RE: Strole Agriculture Short Plat, SP-15-00009

Enclosed are the comments received regarding the Strole Agriculture Short Plat (SP-15-00009):

SUBJECT: Strole Ag Short Plat SP-15-00009

**STROLE AG SHORT PLAT
SP - XX-XX**
A PORTION OF THE W 1/2 OF SECTION 35, TOWNSHIP 19
NORTH, RANGE 18 EAST, W.M. KITTITAS COUNTY,
WASHINGTON

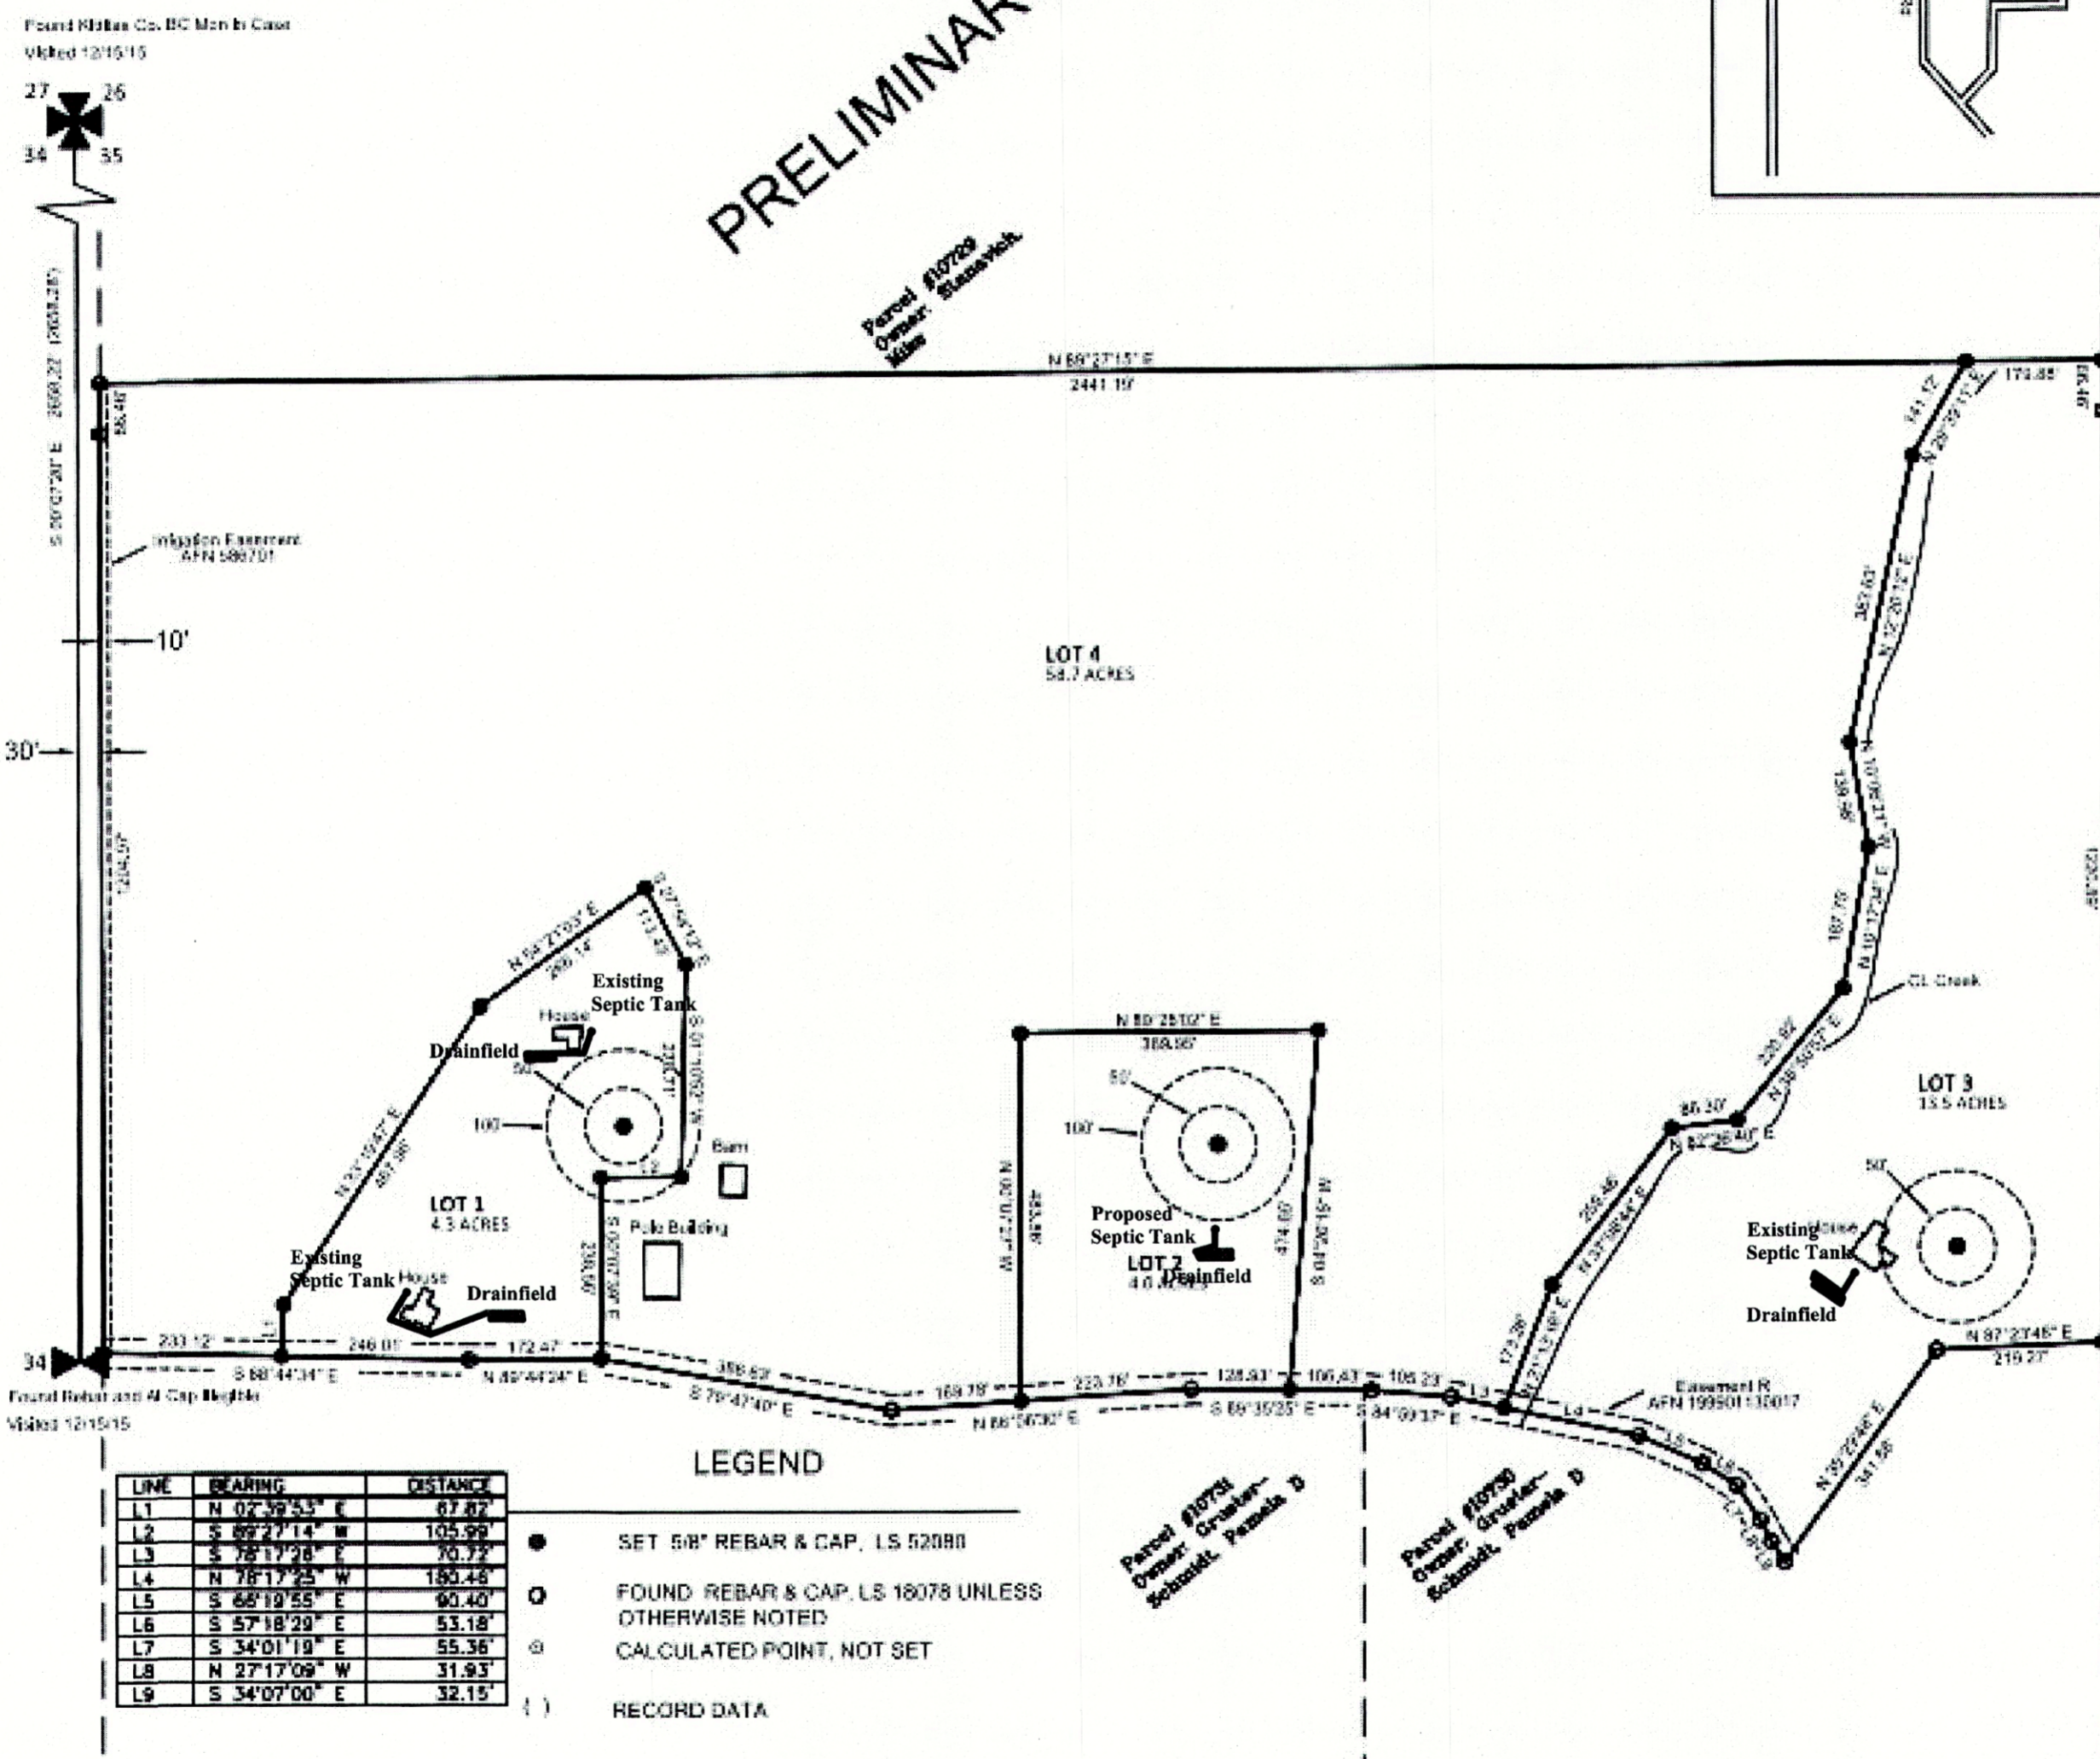
1. Floodplain: Needs to be depicted on the face of the Short Plat
2. Timing of Improvements: This application is subject to the latest revision of the Kittitas County Road Standards, dated 12/15/15. The following conditions apply and must be completed prior to final approval of this project. A performance guarantee may be used, in lieu of the required improvements, per the conditions outlined KCC12.01150.

4. Private Road Improvements: Access from Robbins Road shall be constructed as a Low-Density Private Road. See Table 4-4, current Kittitas County Road Standards, 12/15/15 edition.

- a. Access easements shall be a minimum of 60' wide. The roadway shall have a minimum width of 20', with 1' shoulders, for a total width of 22'.
  - b. Minimum centerline radius will be 60'.

- c. The surface requirement is for a minimum gravel surface depth of 6".
  - d. Maximum grade is 10%.
  - e. Stopping site distance, reference AASHTO.

- i. All easements shall provide for AASHTO radius at the intersection of county road.
  - j. A paved apron shall be constructed at the intersection of the proposed private intersection and the county road right of way.

6. Turnaround: When a road extends more than 150' from the centerline of a County road or other publicly maintained road or serves more than three lots, a turnaround shall be provided. The turnaround shall be a cul-de-sac for roads serving five or more lots/units. The turnaround may be a hammerhead for roads serving four or less lots/units or for a land use development activity occurring prior to the end of the road. Cul-de-sac and hammerhead designs must conform to the specifications of the International Fire Code. A cul-de-sac shall have an easement diameter of at least 110 feet and a driving surface of at least 96 feet in diameter.

A wetland delineation should be done for proper placement of building envelopes and roads. Lots should be designed which do not require intrusion into wetland areas or their required buffers zones for access or infrastructure (wells and utilities, etc.) and buildings. The National Wetland inventory maps may not show the full extent of wetlands or their exact location and therefore on-site investigation to identify wetland areas should be required before final lot line locations and building permits are approved.
